STATE OF NORTH CAROLINA DEPARTMENT OF TRANSPORTATION

Addendum No. 1

RE: Contract # C204867 WBS # 2023CPT.03.10.10311, 2023CPT.03.10.10312, 2023CPT.03.10.20311, 2023CPT.03.10.20312 STATE FUNDED **Duplin County** 1 SECTION OF NC-111, 1 SECTION OF NC-903, AND 19 SECTIONS OF SECONDARY ROADS

March 21, 2023 Letting

Duplin County 3, 5-6, 15-18, 21

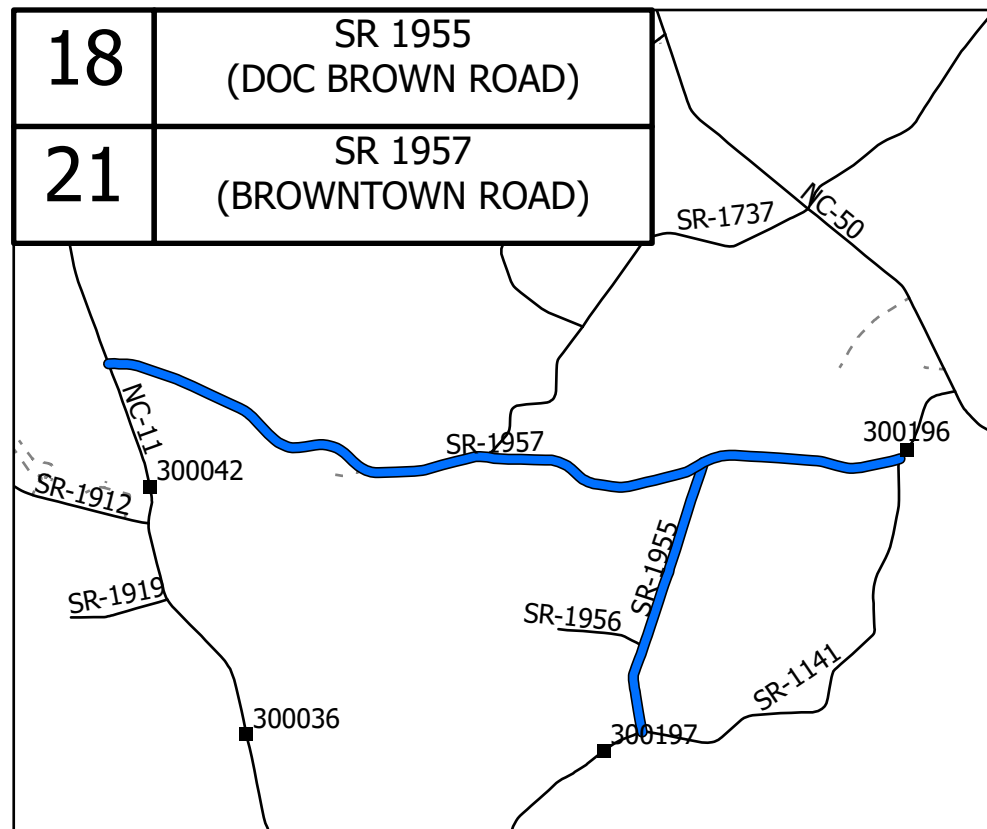
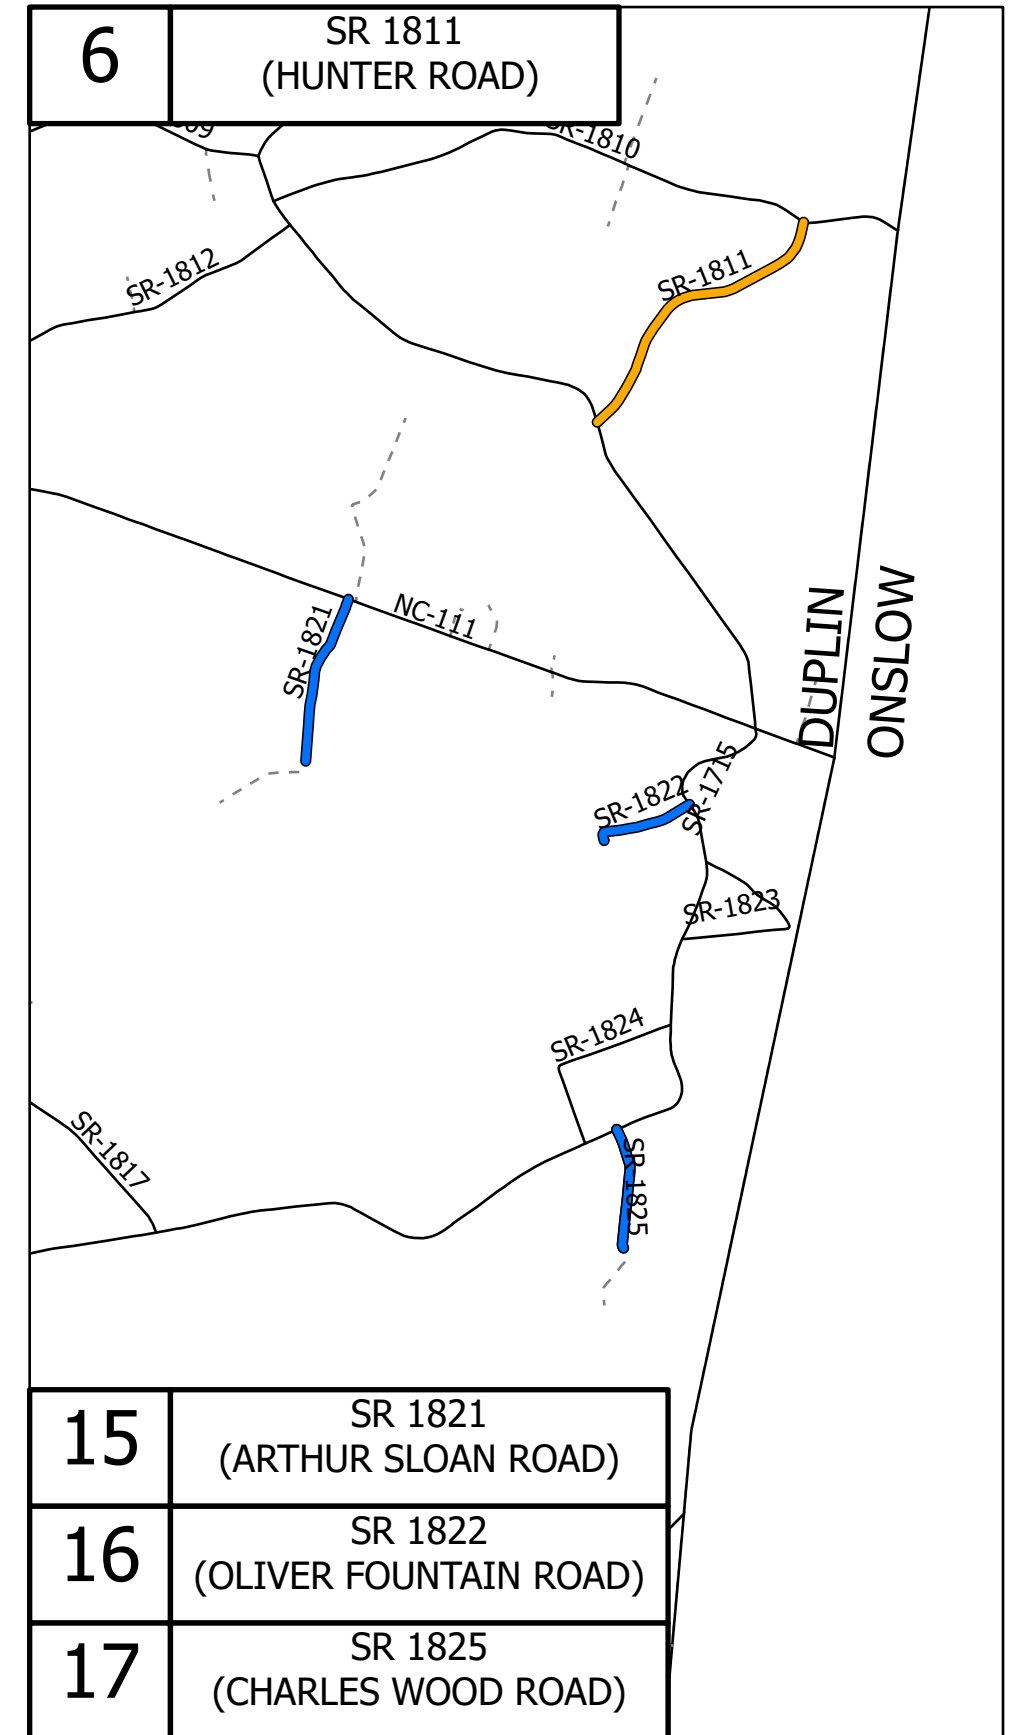
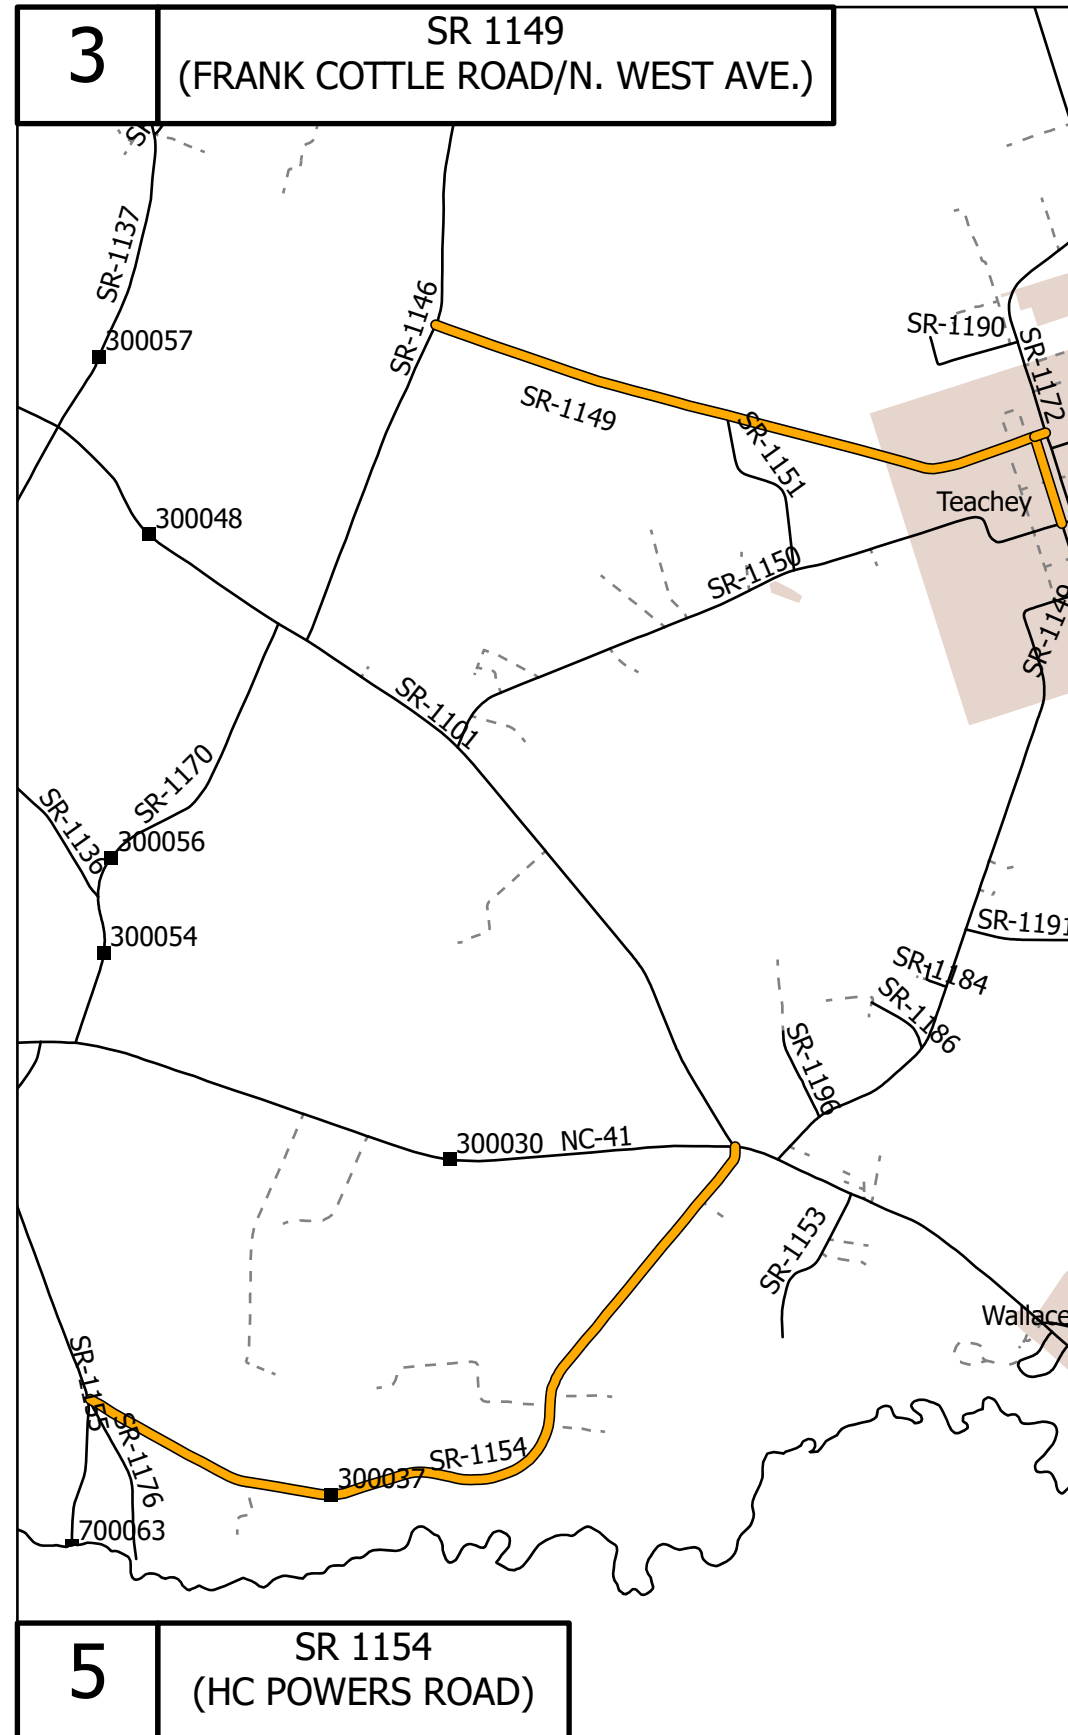
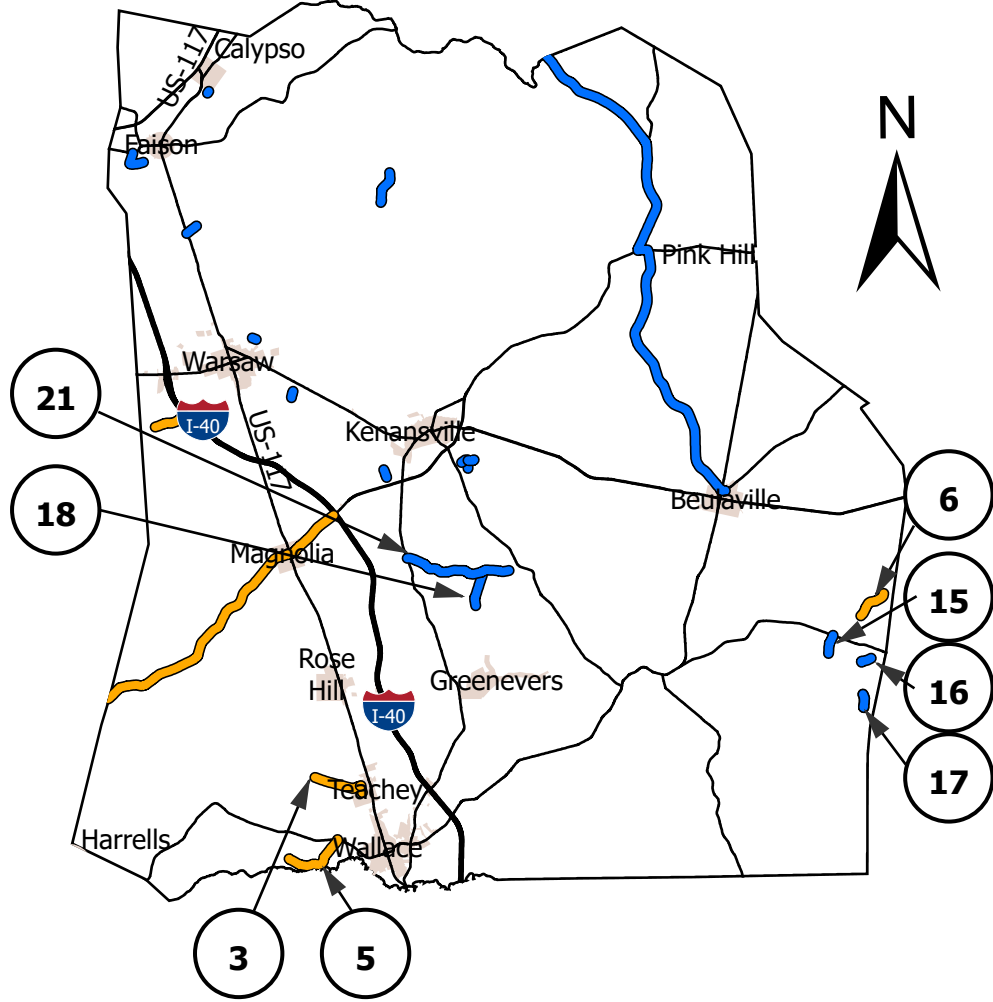
Sheet No.	Revision
15-16	State Furnished Borrow Excavation item added.

Item	Description	<u>Old Quantity</u>	<u>New Quantity</u>
0042-023400000-Е-	STATE FURNISHED	NEW ITEM	2,806 CY
SP	BORROW EXCAVATION
